CITY OF ALBUQUERQUE

February 10, 2020

**Re: Monterey Place Apartments – 2306 Central Ave SW
Erosion Sediment Control Plan
Engineer's Stamp Date 12/13/19 (J12E030)**

EROSION CONTROL PLAN - MONTEREY PLACE APARTMENTS

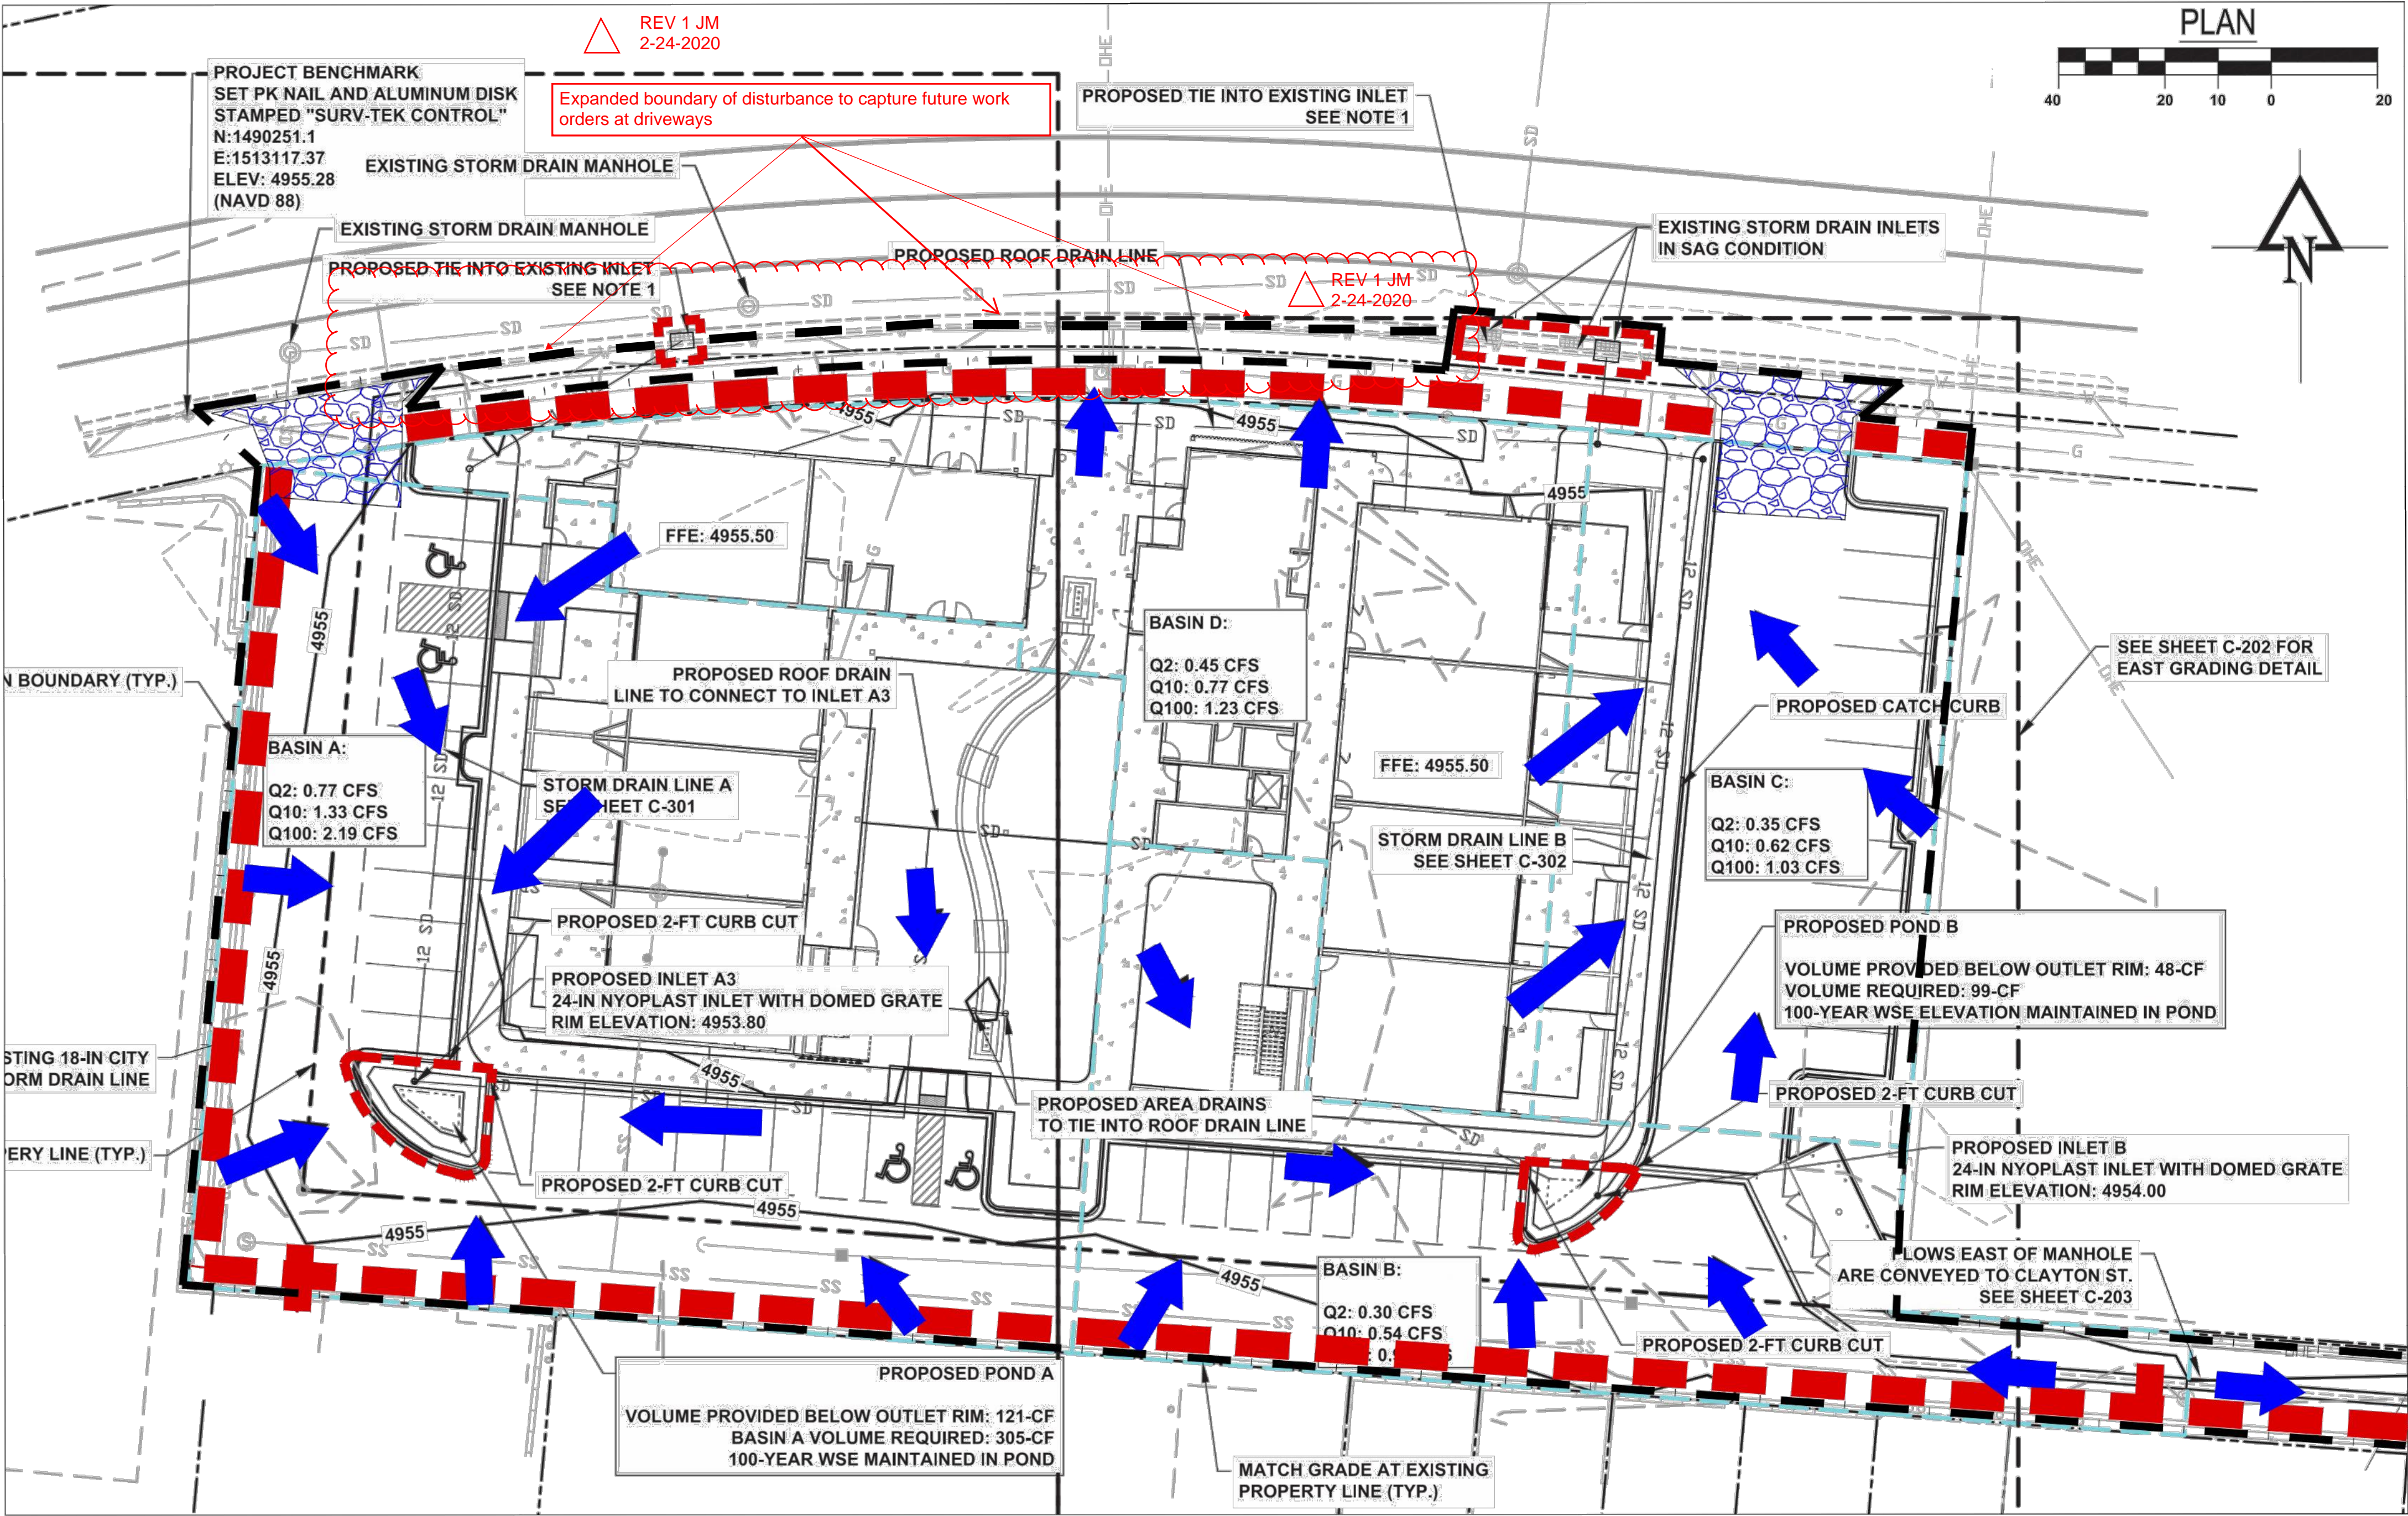
1. The wording of Erosion Control Note # 3 is inconsistent with the criteria in CGP 2.2.14.b. and should be deleted. The 70% criteria refers only to the portion of the site not covered by structures, and further refers to the minimum density of permanent vegetation where only vegetation is used. It also says there should not be any large bare areas. City standard notes 3 and 4 address the issue of final stabilization (see below).
